PLANNING BOARD REPORT PORTLAND, MAINE

Hotel Redevelopment
1210 Brighton Avenue
Level III Site Plan Review
2014-220
Portland Hotels, Inc., Applicant

Submitted to: Portland Planning Board Public Hearing Date: April 14, 2015 (<i>tabled from March 24, 2015</i>)	Prepared by: Nell Donaldson, Planner Date: April 8, 2015 CBL: 265-A-001
--	---

Sheet Title:
PAVEMENT MARKING AND SIGNAGE PLAN

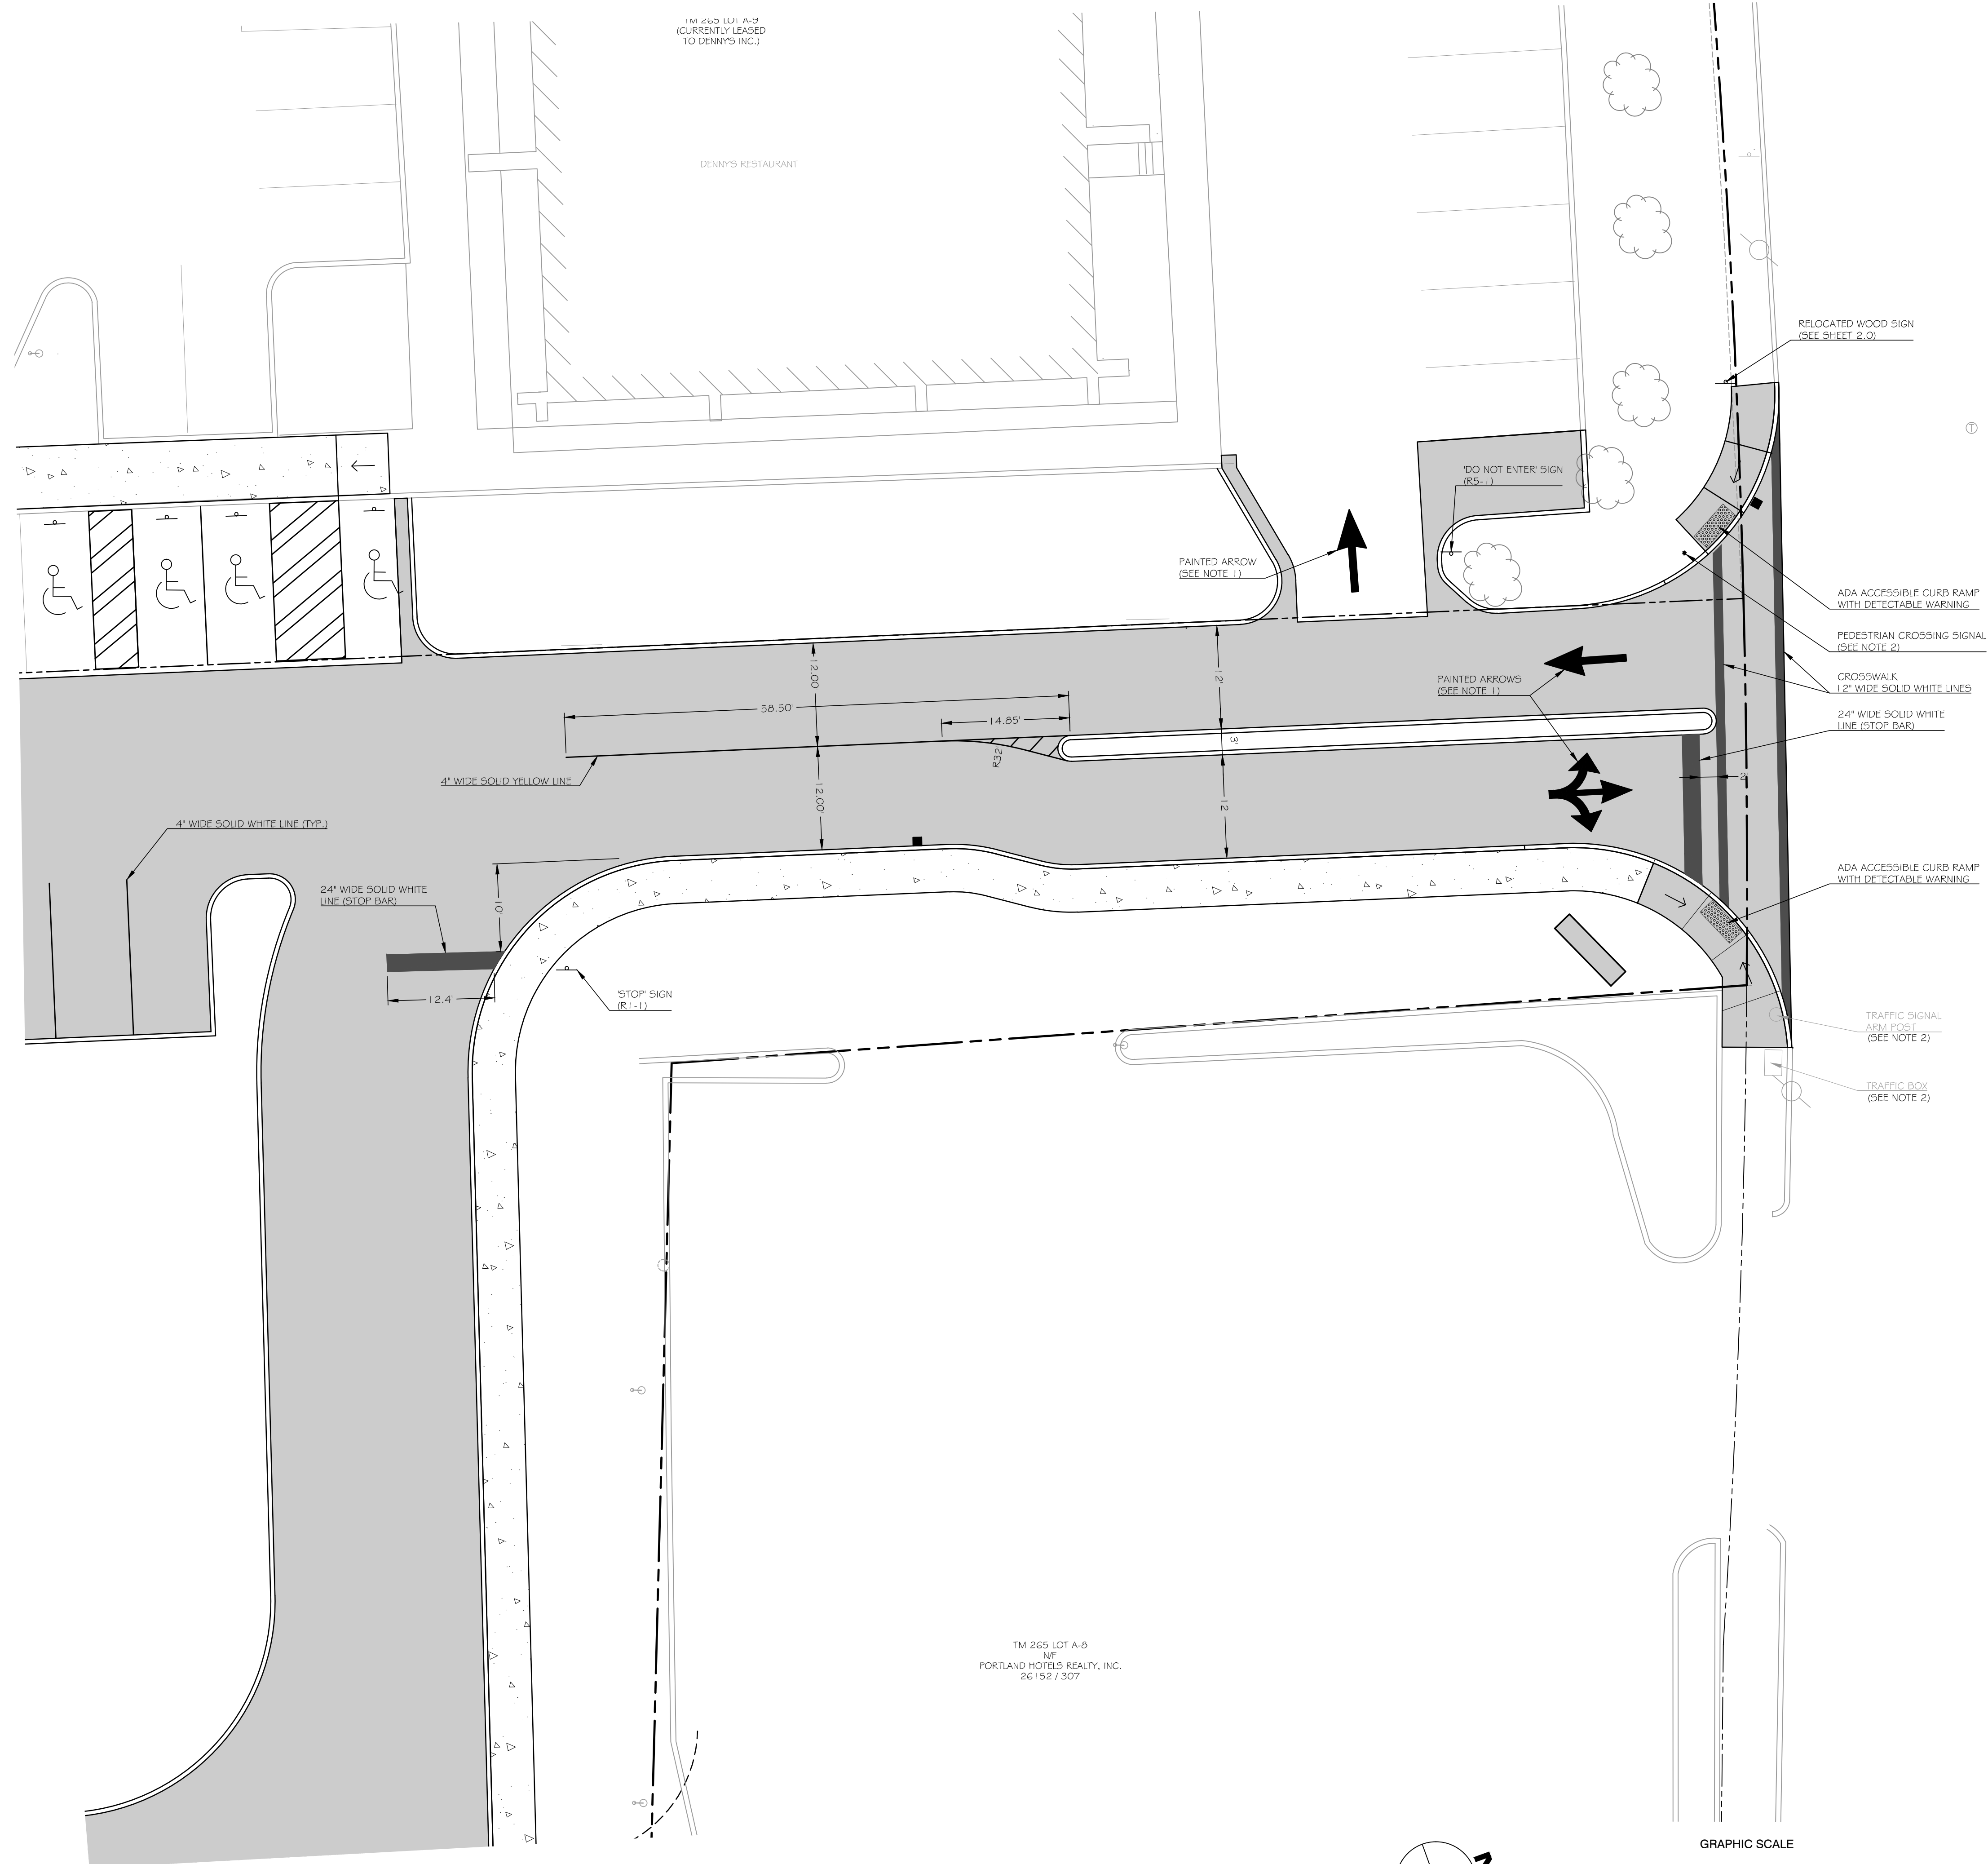
Vehicular access is proposed via a private driveway which forms the fourth leg of the Brighton Avenue/Riverside Street intersection. This drive also serves as the sole vehicular access for Denny's. The applicant proposes a 75' island at this entrance in order to reduce potential vehicular conflicts with cars exiting from Denny's. The applicant complied with staff requests to relocate existing Denny's parking spaces currently positioned on the entrance drive in order to further improve the safety at the site entrance. The applicant also provided a detailed pavement marking plan for the entrance drive at staff's request (*Plan 20*).

Pedestrian access to and from the site is proposed via a sidewalk, located on the eastern side of the driveway, which connects to all proposed building entrances. This sidewalk would link to both the Brighton Avenue sidewalk system and the Brighton Avenue crosswalk, which traverses the eastern leg of the Brighton Avenue/Riverside Street intersection and from there provides access to nearby food and shopping in Westbrook. Mr. Errico requested that the applicant provide a crosswalk across the site driveway at Brighton Avenue. The applicant shows this crosswalk in their final plans. In his final comments, Mr. Errico notes,

The applicant has provided the requested crosswalk and noted signal modification upgrades. The applicant will be responsible for submitting a traffic signal design plan that details specifications for review and approval by City staff.

2. The applicant shall submit a traffic signal design plan for the Brighton Avenue/Riverside Street intersection for review and approval by the Department of Public Services;

**BOUNDARY & TOPOGRAPHIC SURVEY**  
AT  
1200 BRIGHTON AVENUE, PORTLAND, MAINE  
MADE FOR  
**WALSH ENGINEERING**  
1 KAREN DRIVE #2A, WESTBROOK, ME 04092

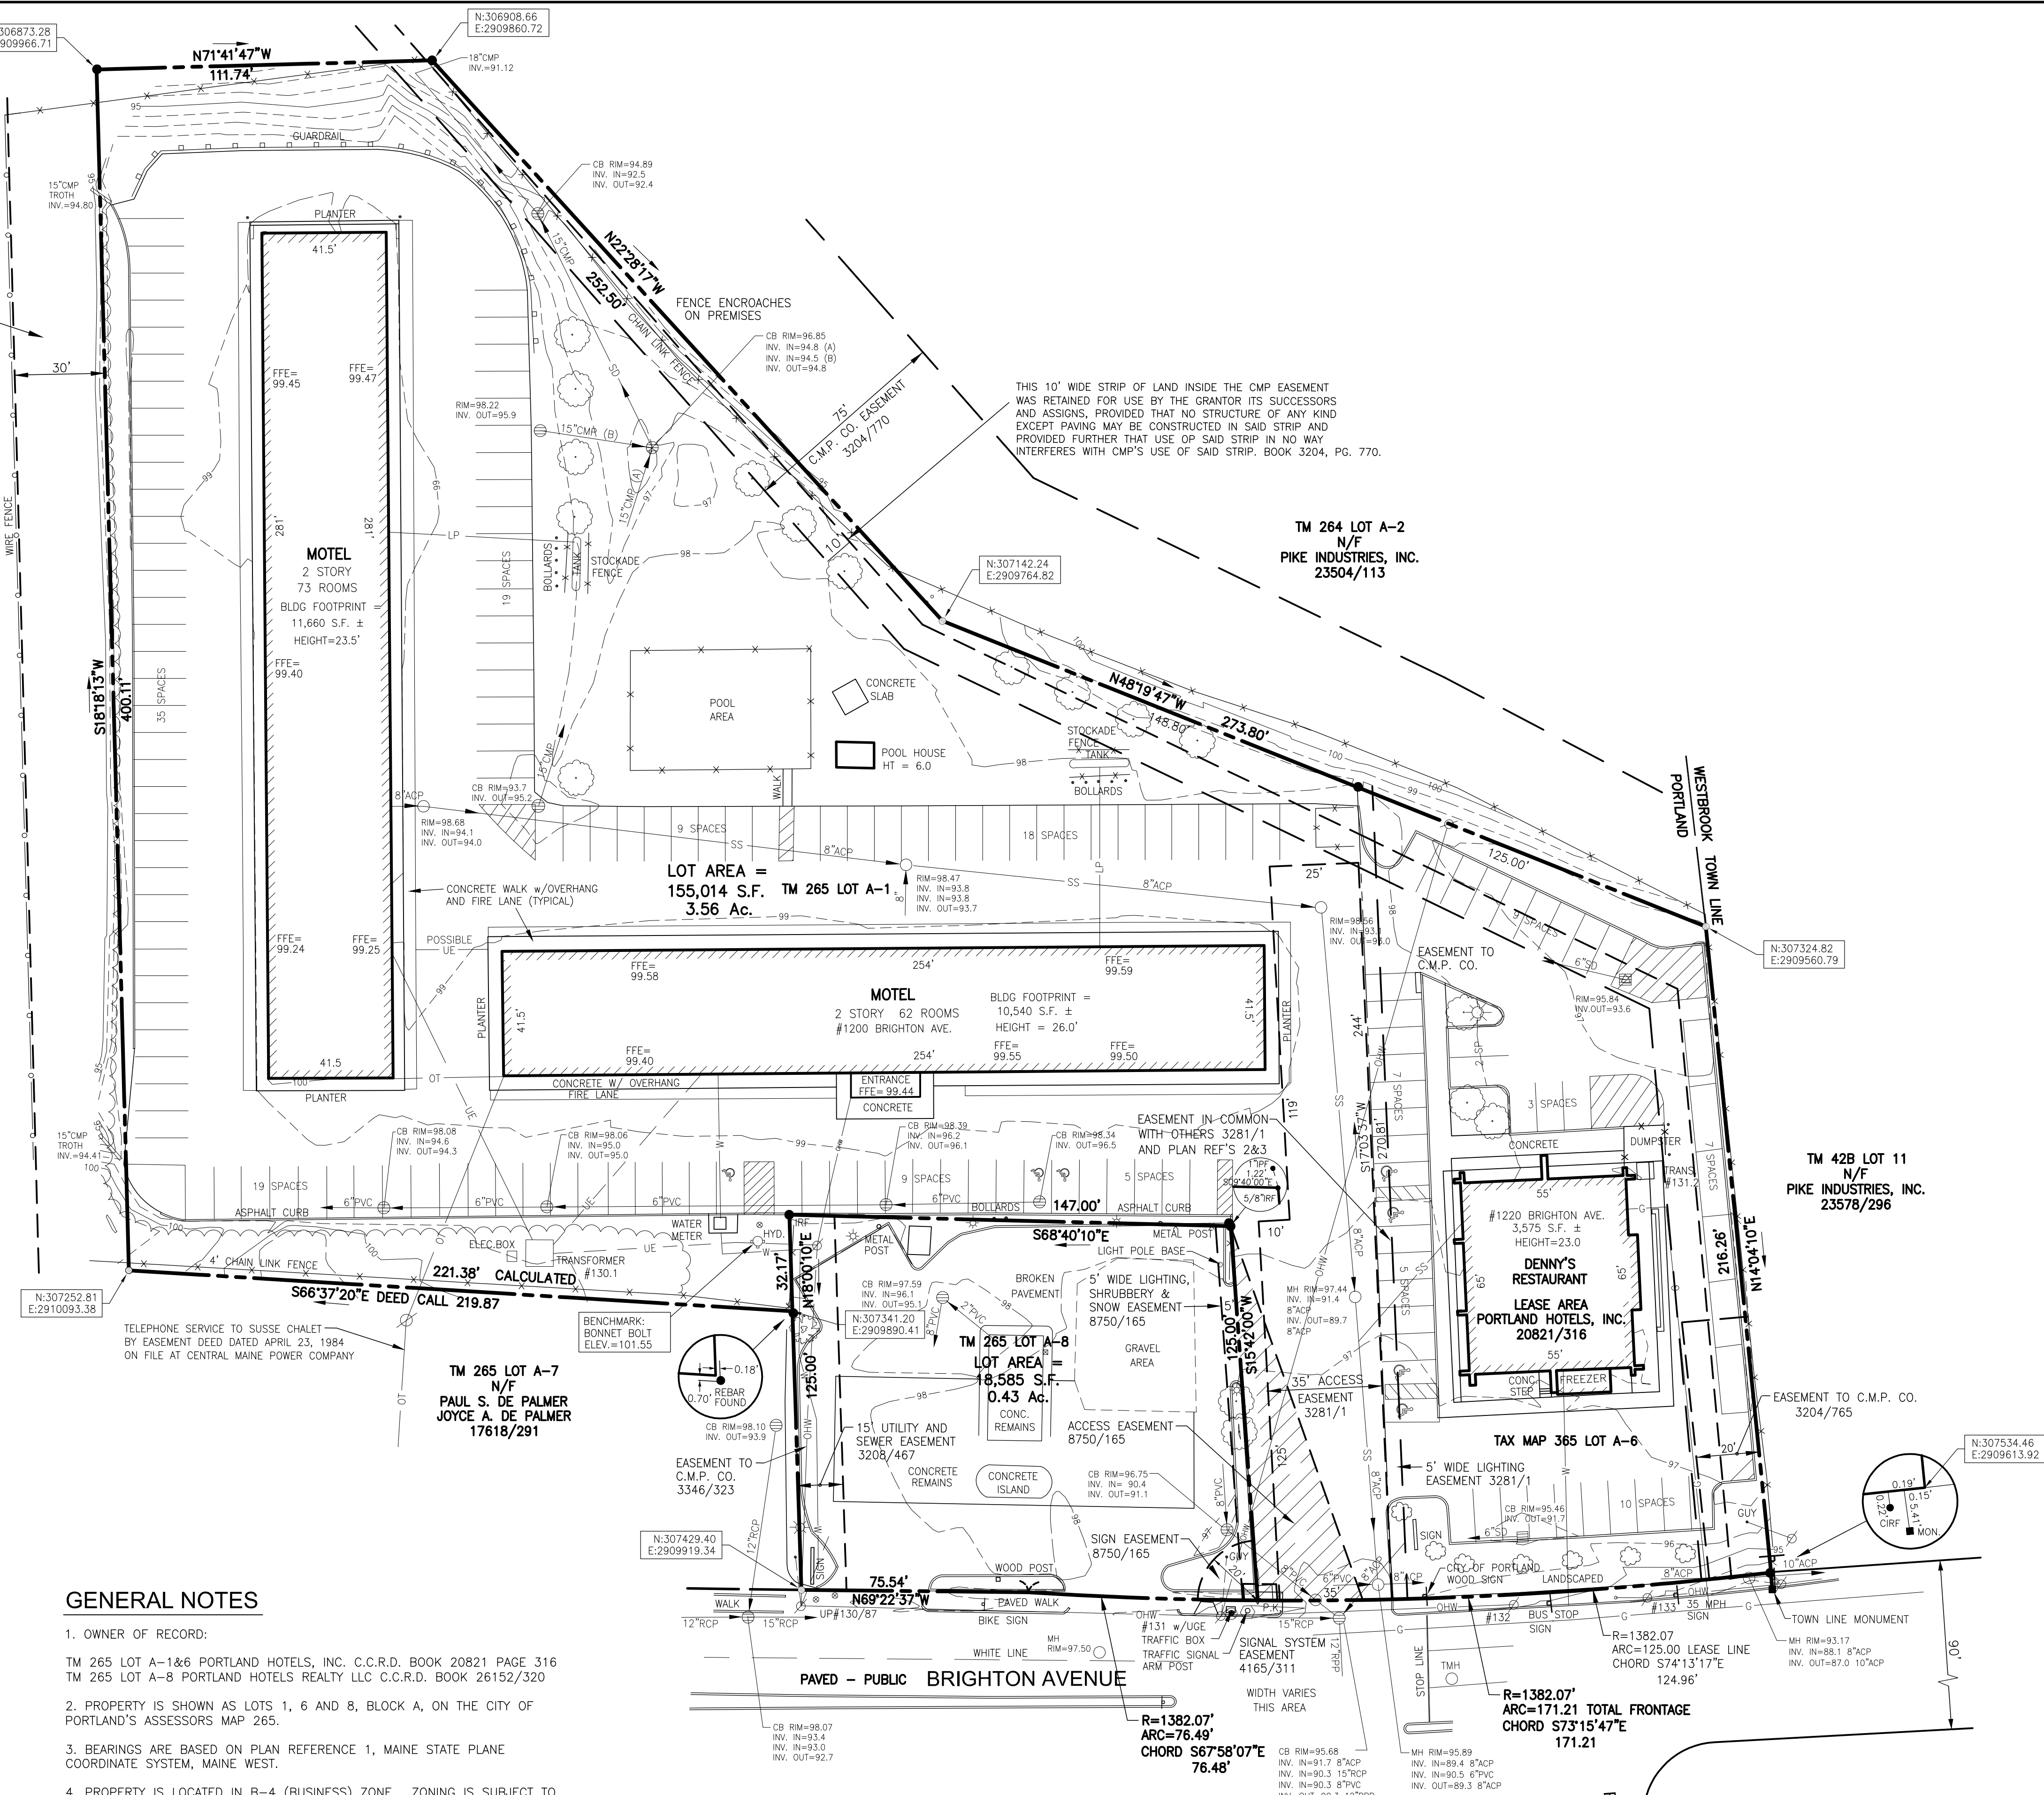
The applicant's submittal includes a deed as evidence of right, title, and interest (*Attachment F*). As noted above, this deed includes reference to a 1972 lease conveyed to Harold Butler Enterprises (then parent company of Denny's) for the western portion of the site. The site is also subject to multiple easements, which are included in the submittal and depicted on the boundary survey prepared by Owen Haskell (*Attachment M and Plan 2*). These include:
